REQUEST

Current Zoning: N1-A (neighborhood 1-A).
Proposed Zoning: N2-A(CD) (neighborhood 2-A, conditional)

Approximately 2.67 acres located at the southeast intersection of Sardis Road and Timber Lane, east of Providence Road.

PLANNING STAFF REVIEW

RZ-1.0

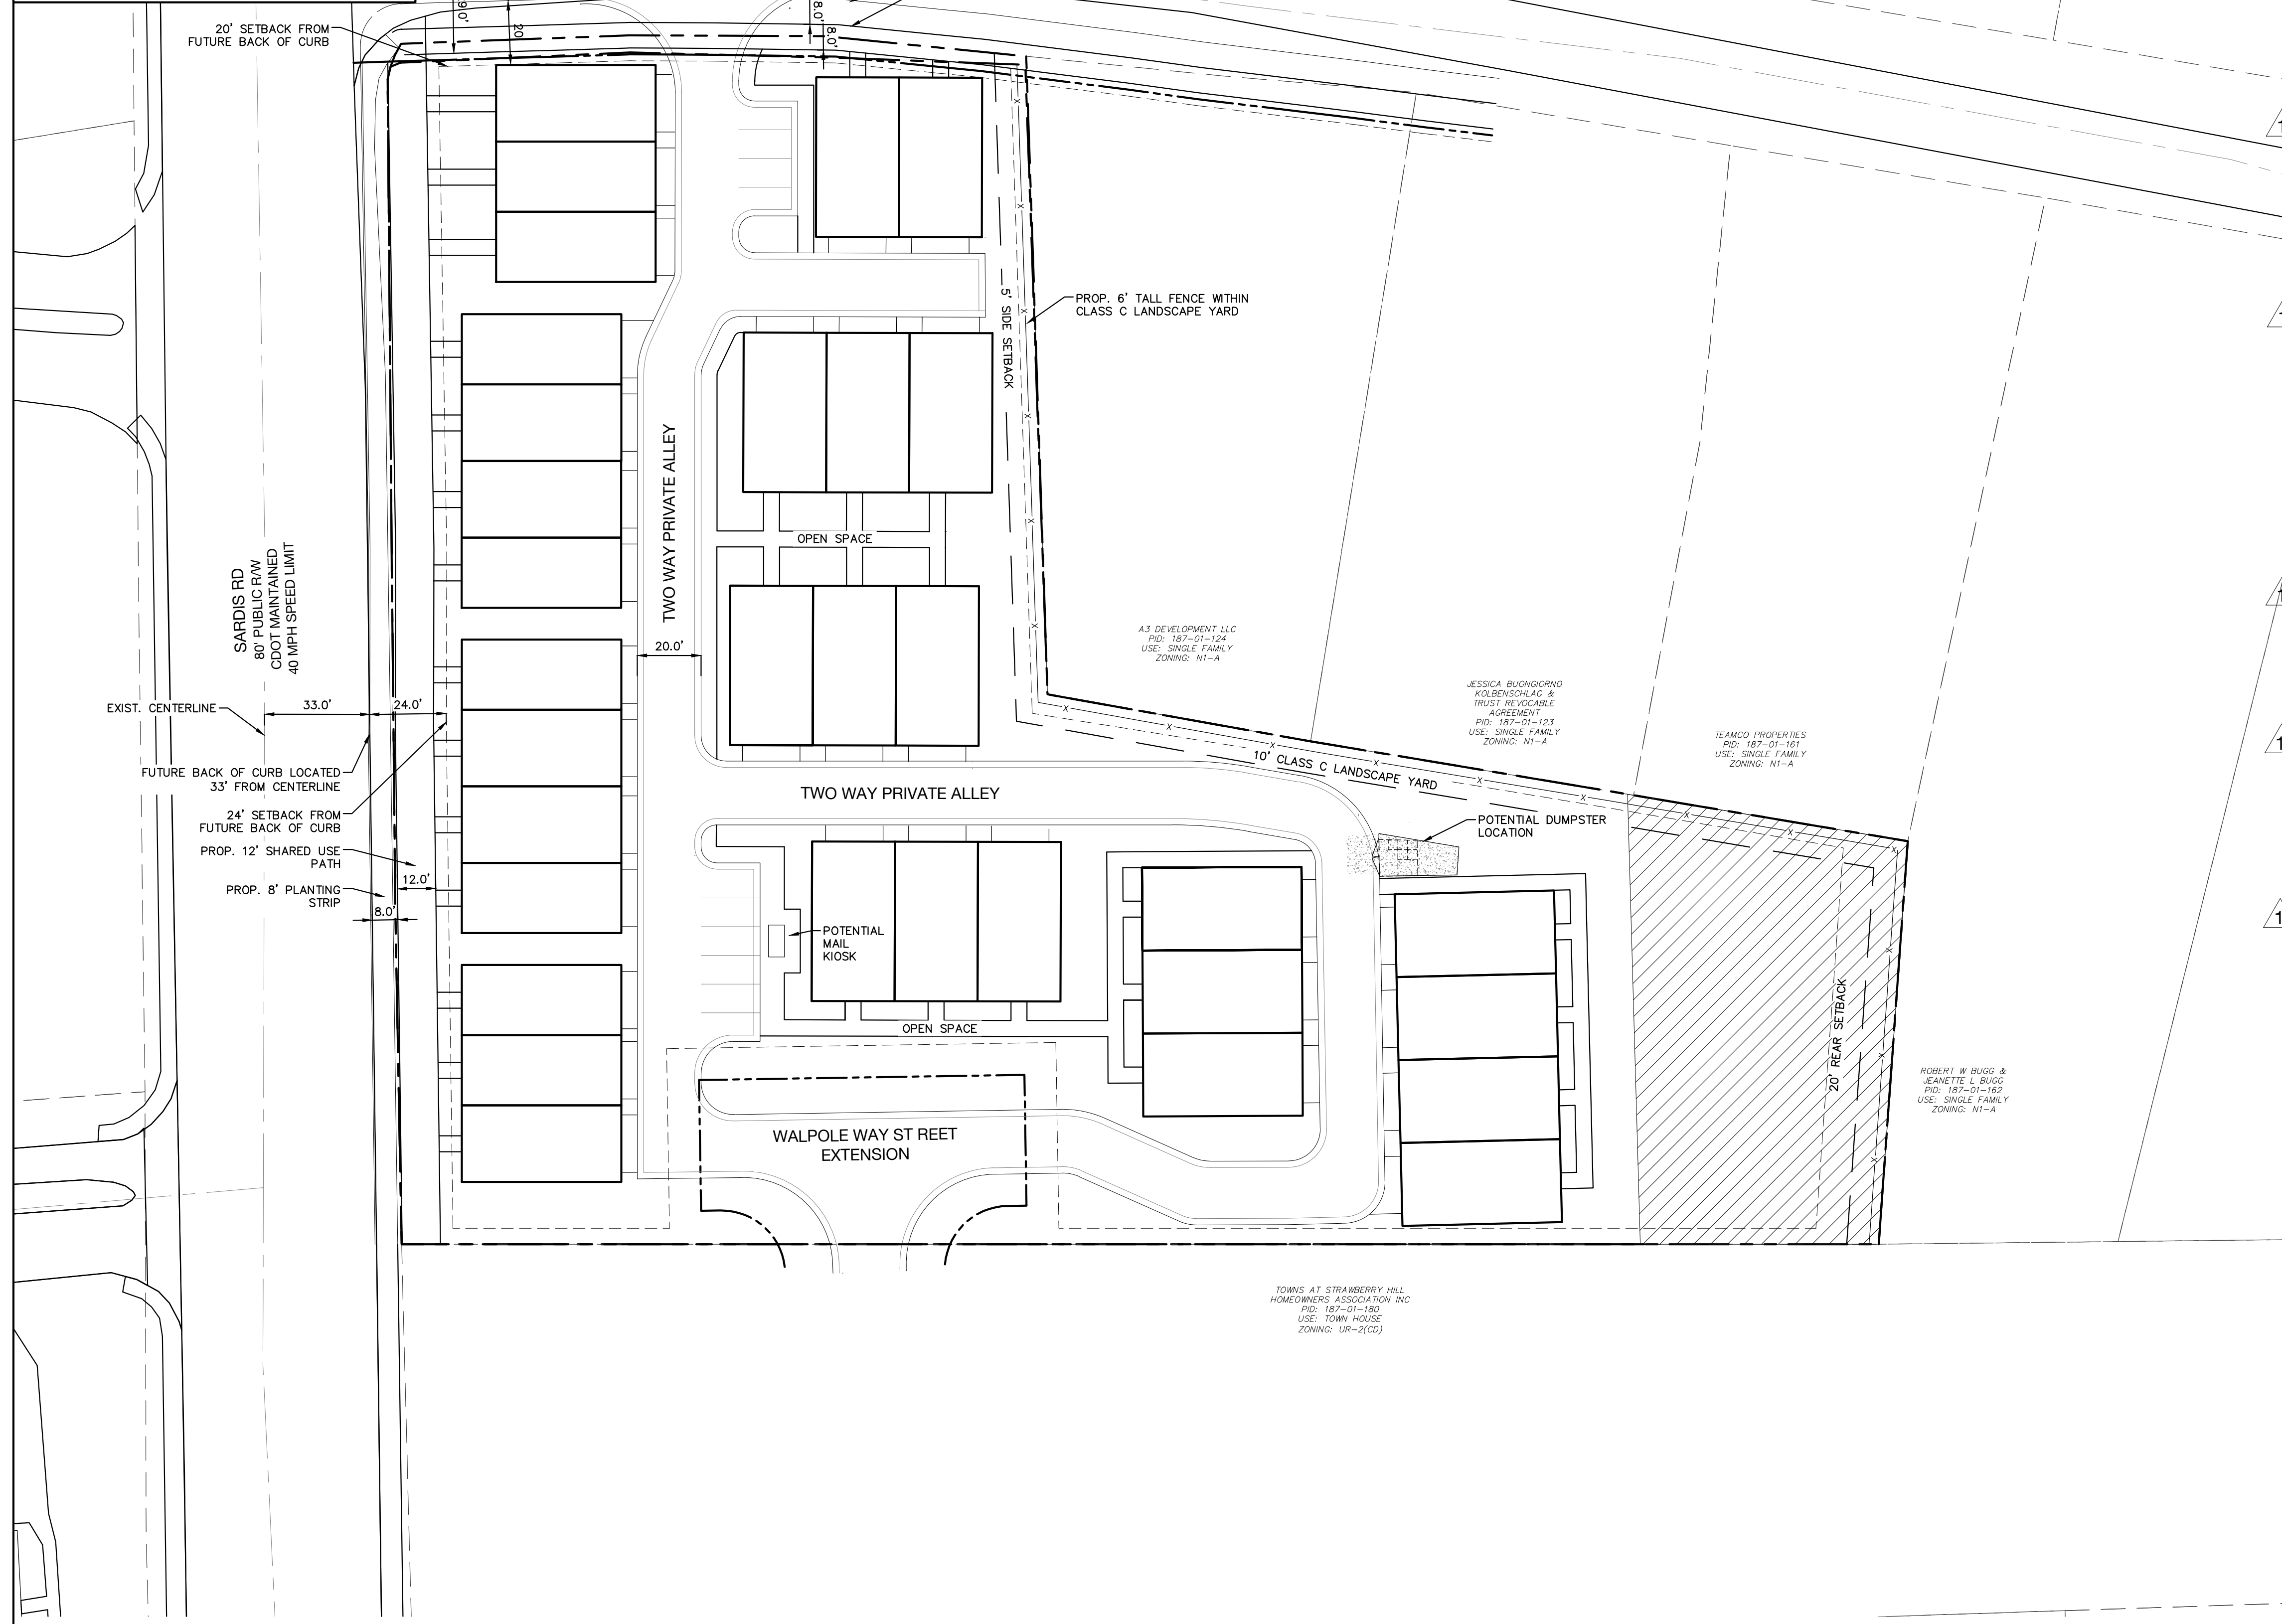
Urban Forestry: Development Data table states .40 acres of tree save required, but the plan shows roughly .25 acres. **Addressed**

5. Entitlement Services: Entitlement Services: a height limit or height transition should be provided for all buildings abutting parcels designated as Neighborhood 1 Place Type. **The height should be limited to 40'. Addressed**

6. Entitlement Services: A sidewalk should be added along the right in/right out driveway, connecting the multi-use path along Sardis Road/crosswalk across Sardis Road to the sidewalks in the private alley network. **Addressed**

7. Entitlement Services: Additional visitor parking should be added where feasible. The visitor parking located adjacent to Timber Lane should be moved to a less visible location or screened to the greatest extent practicable. **Addressed**

8. Entitlement Services: The proposed solid waste facilities area should be moved to a location farther from the property line and screening standards should be outlined in the conditional notes. **Addressed**

9. Urban Forestry: Actual drip line of heritage trees must be used, not approximations or estimations. Survey of dripline will be needed to use incentive and shown on plans. **Addressed**

10. Entitlement Services: Language of the conditional note General Provision I.1 should be revised to state the proposed use is "multi-family attached." **Addressed**

1. Entitlement Services: General Provisions note V.5 regarding elimination of buffer requirement upon rezoning or redevelopment of adjacent site should be removed. **Addressed**
-
